East Yorkshire Solar Farm Nationally Significant Infrastructure
Project

Registration Comments

March 2024

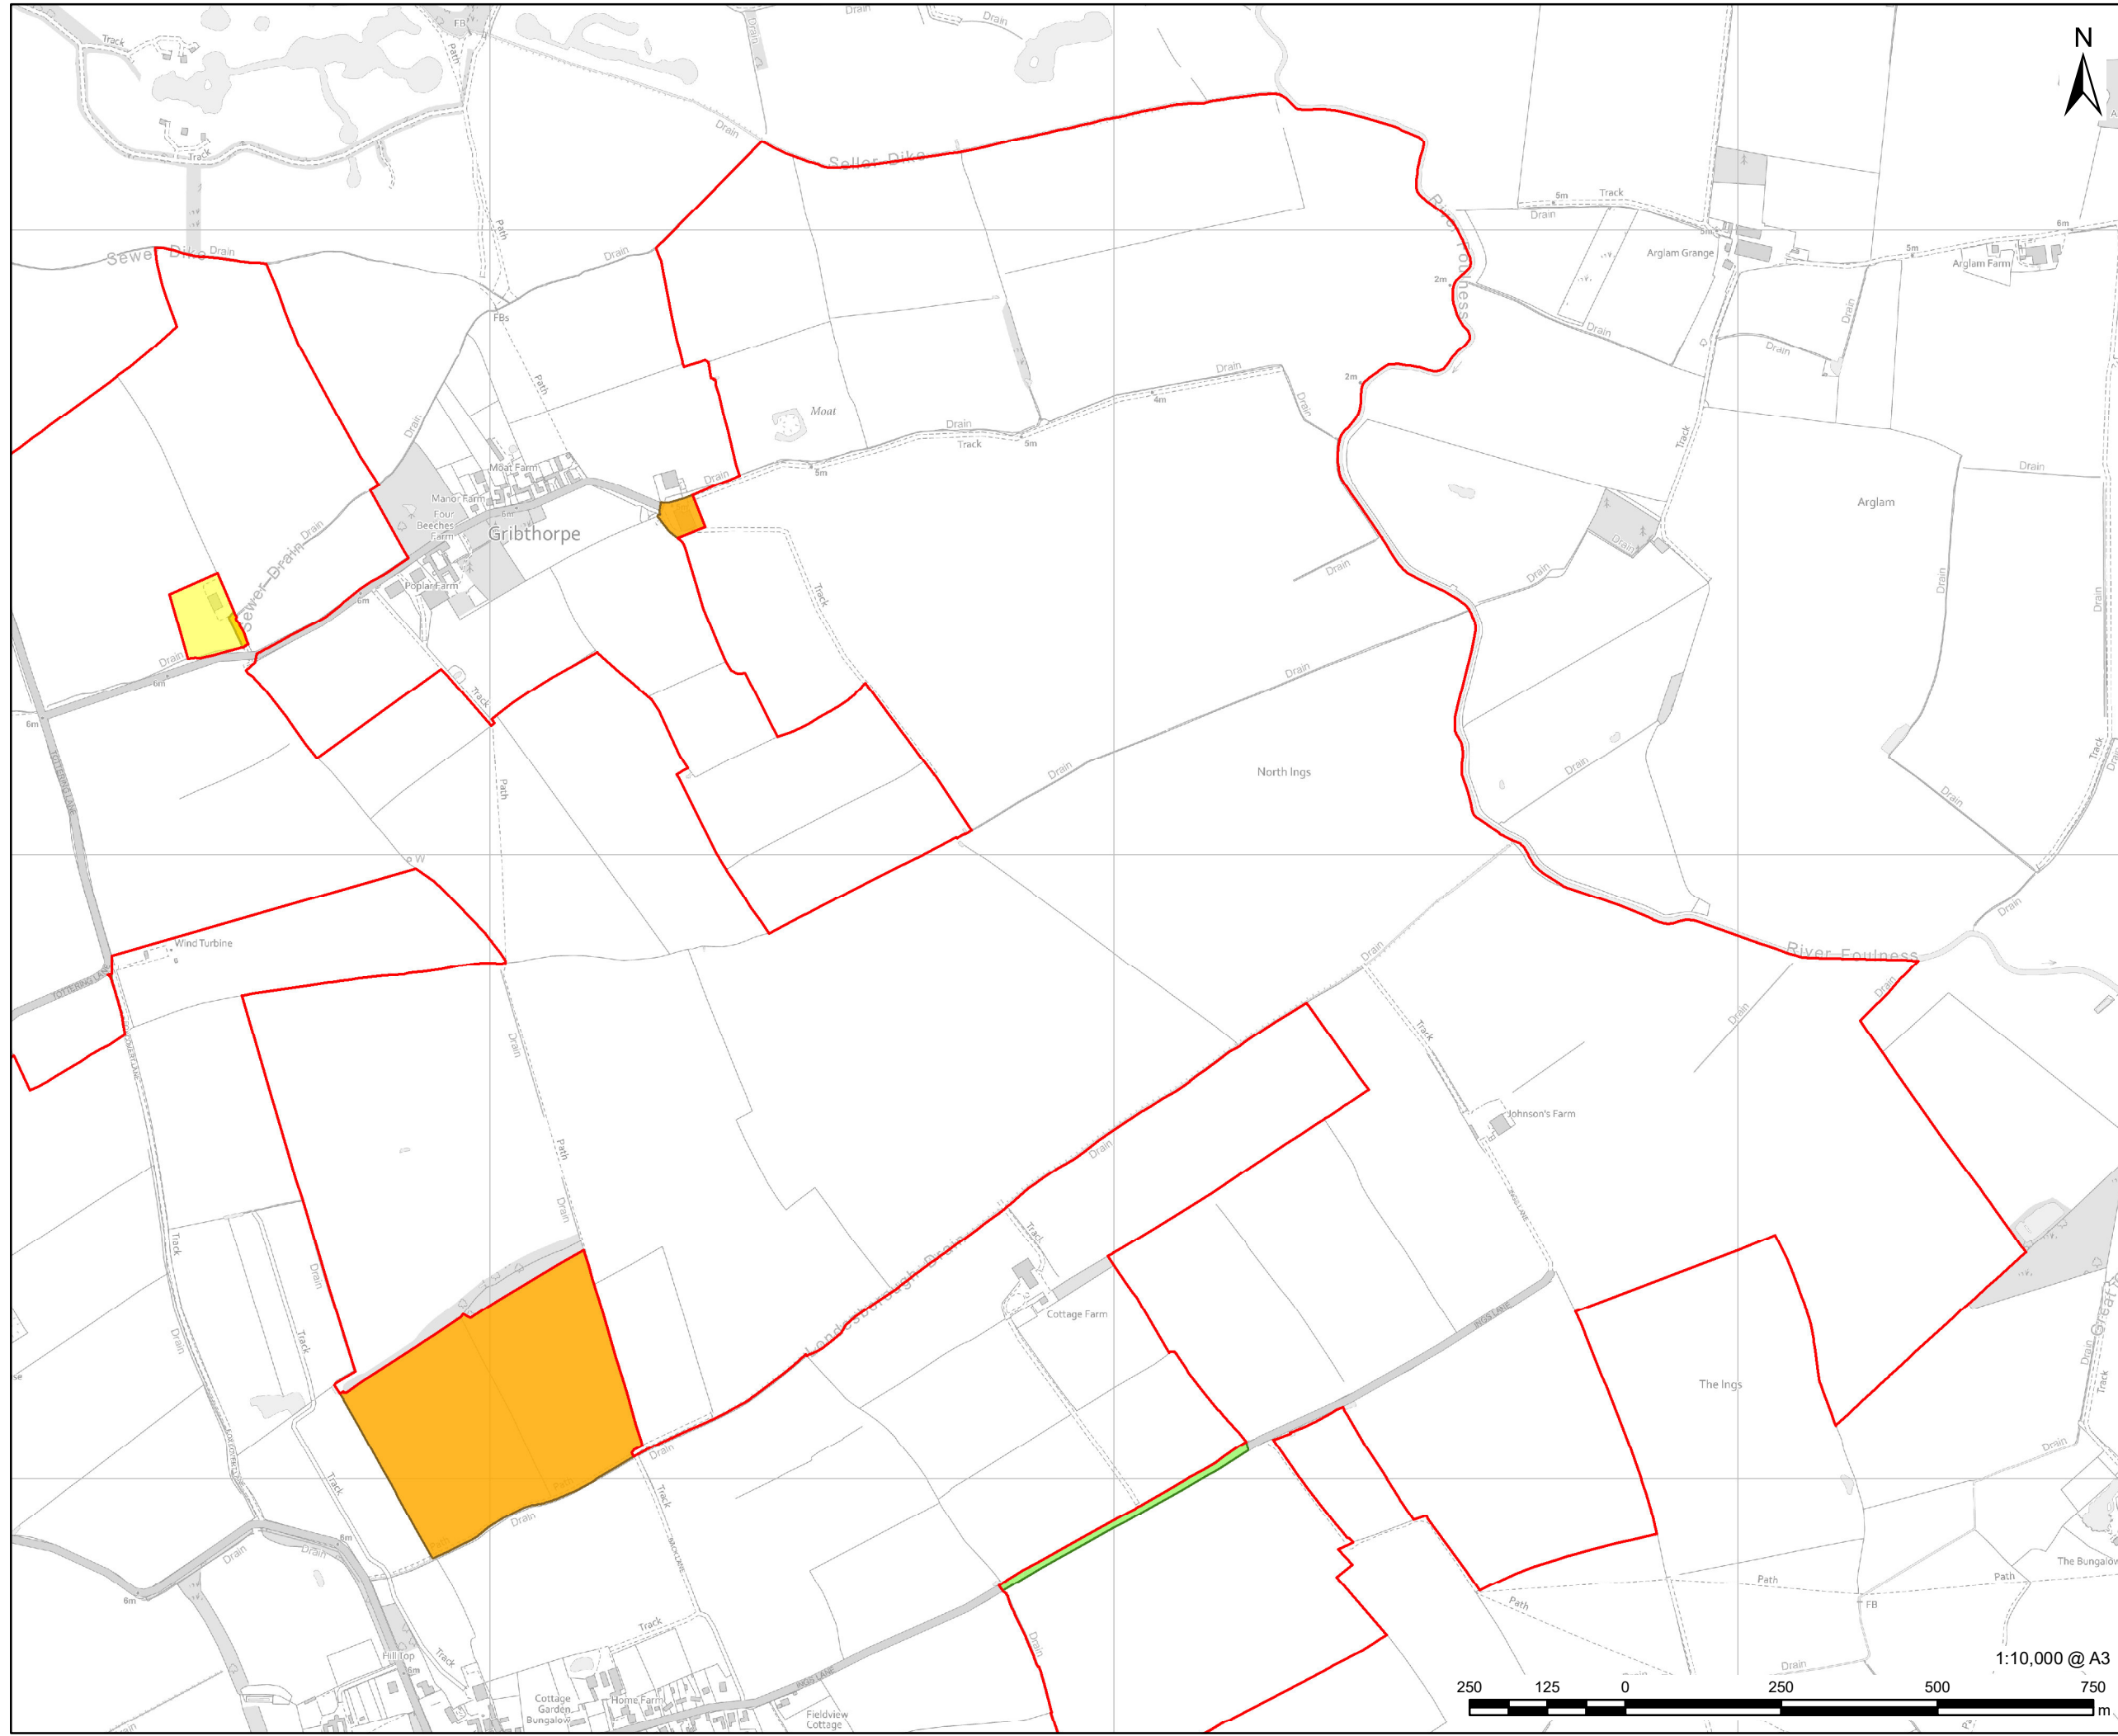
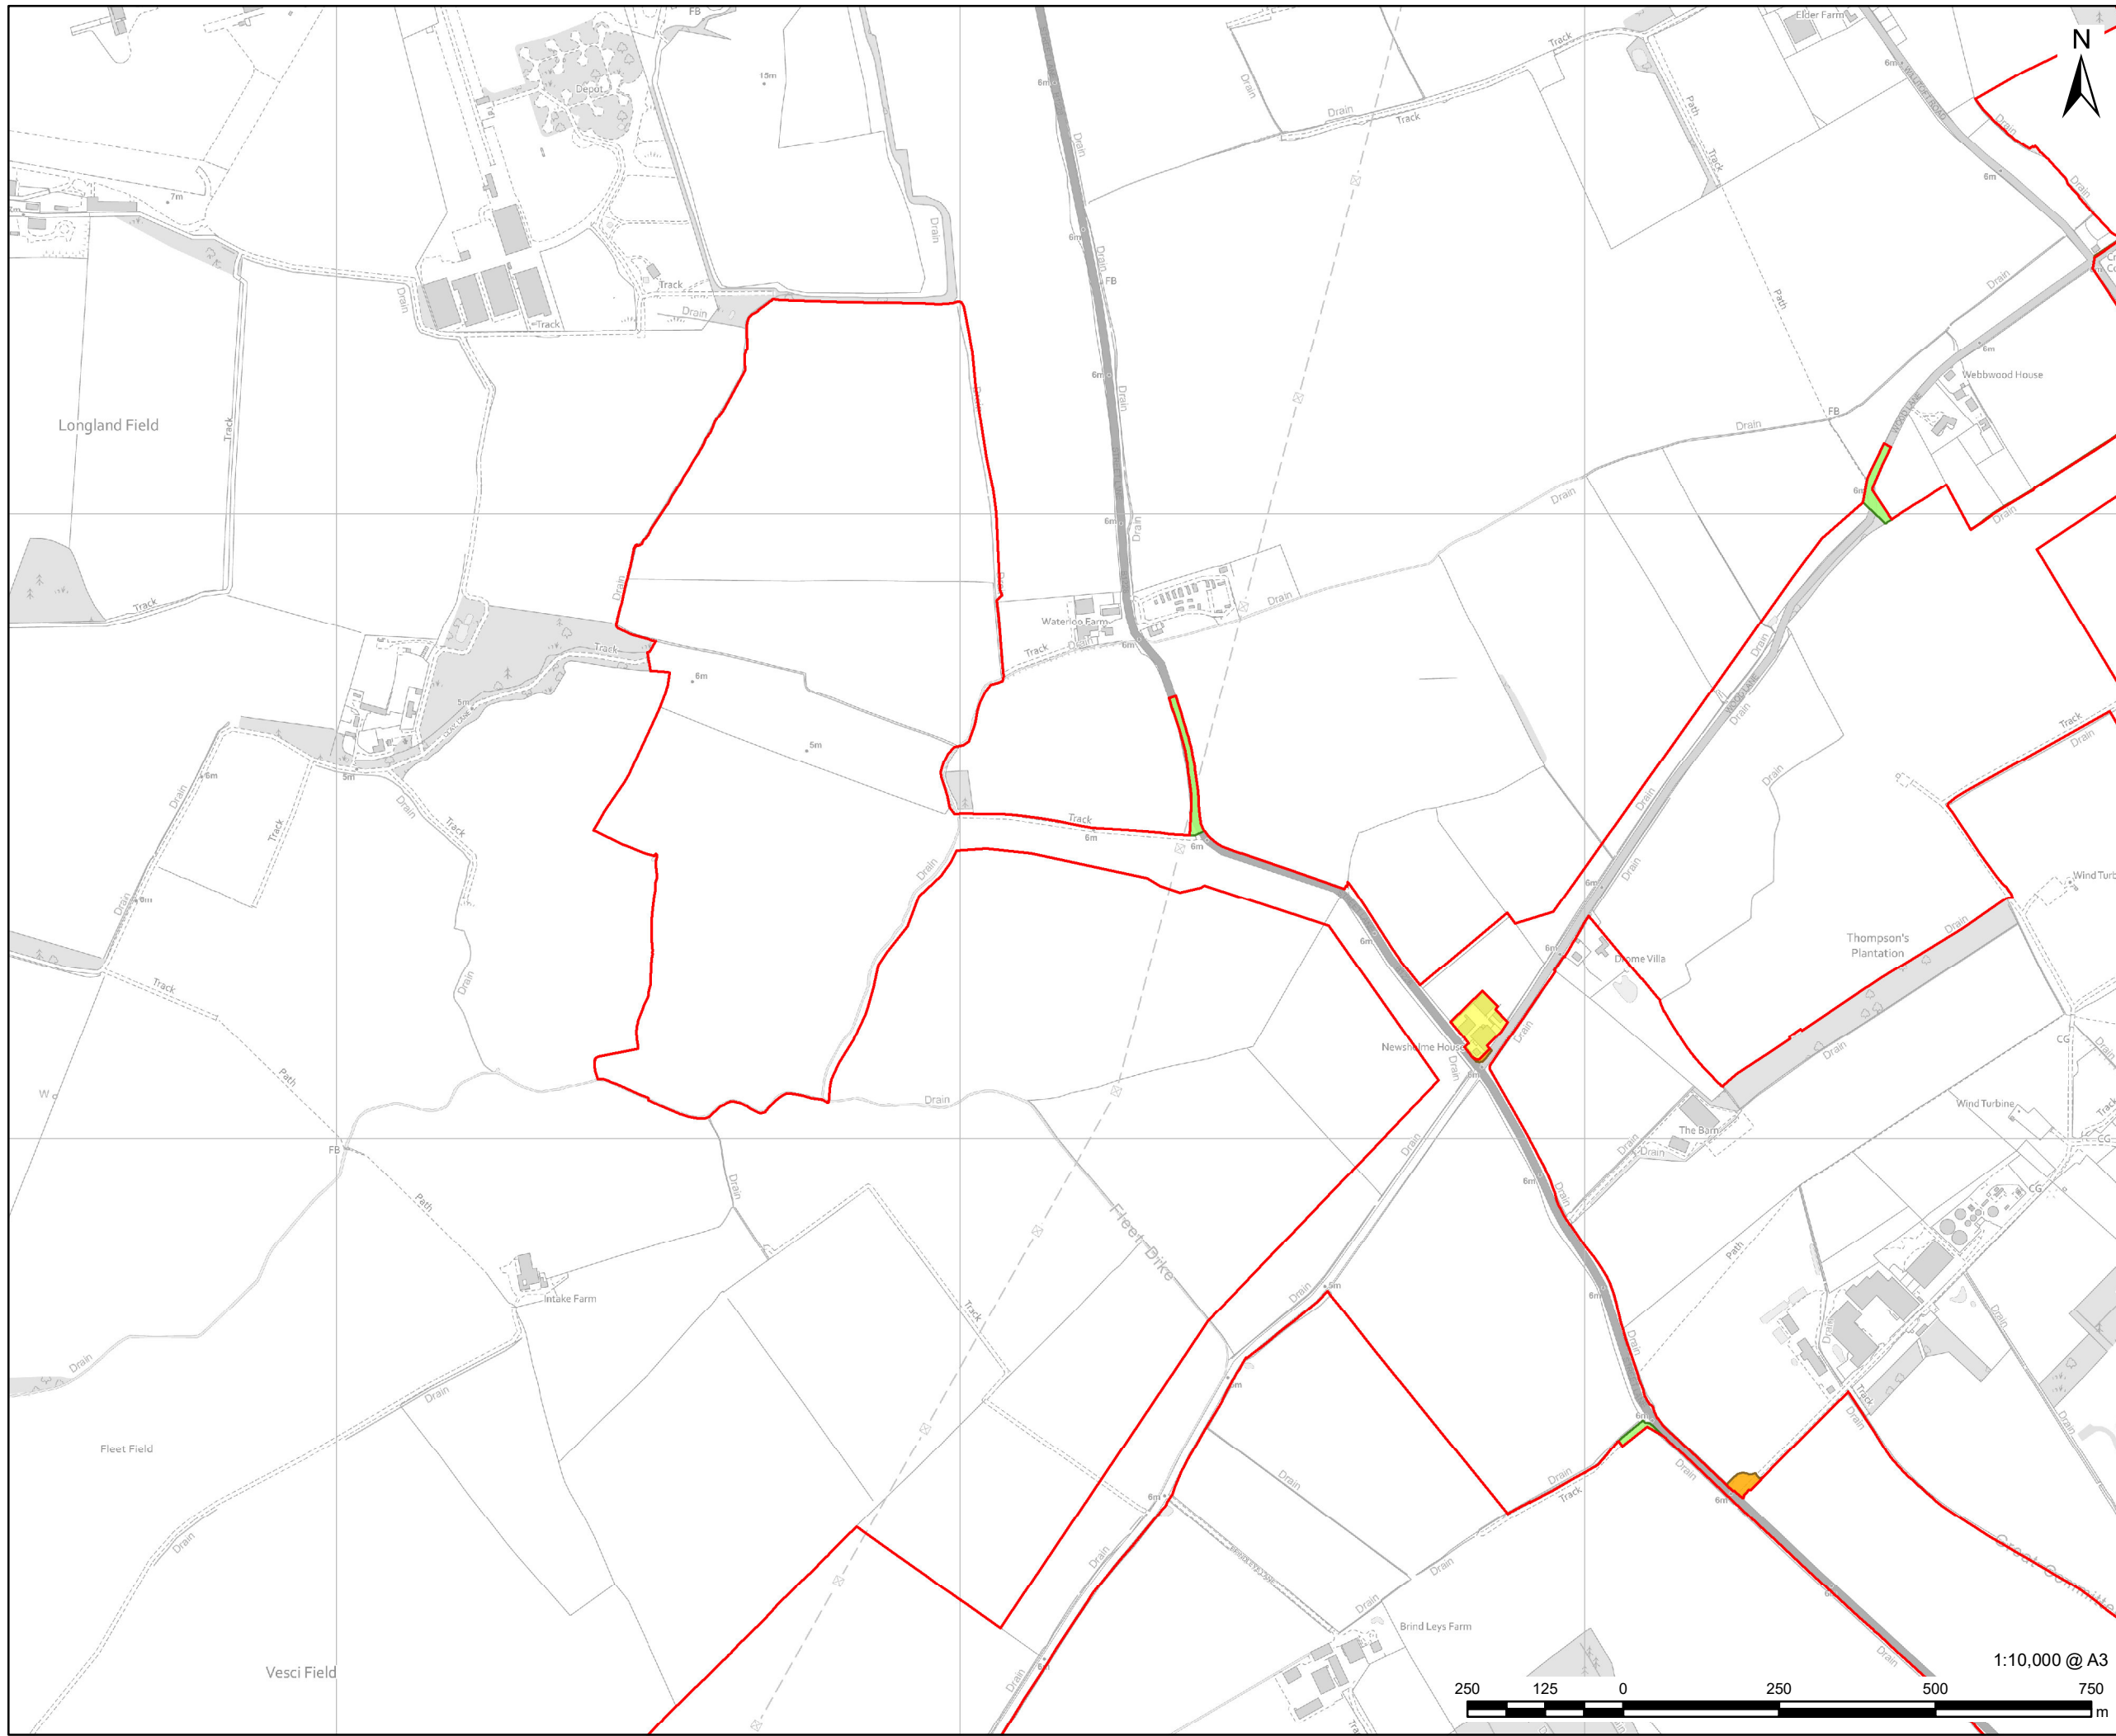
- 2.4. Contrary to this guidance it appears that the applicant has not addressed site-specific issues in relation to our client's property, nor indeed wider issues in relation to impacts on landscape and public rights of way. This is noted from a comparison of the early engagement illustrative plans and the submitted proposal (see **Appendix 1** of this representation). Despite our client writing to the applicant on numerous occasions to raise their concerns, the layout surrounding our client's property has not changed substantially. The same planting scheme appears to have been retained at the north of area 2f and the volume of panels increased in area 2e.
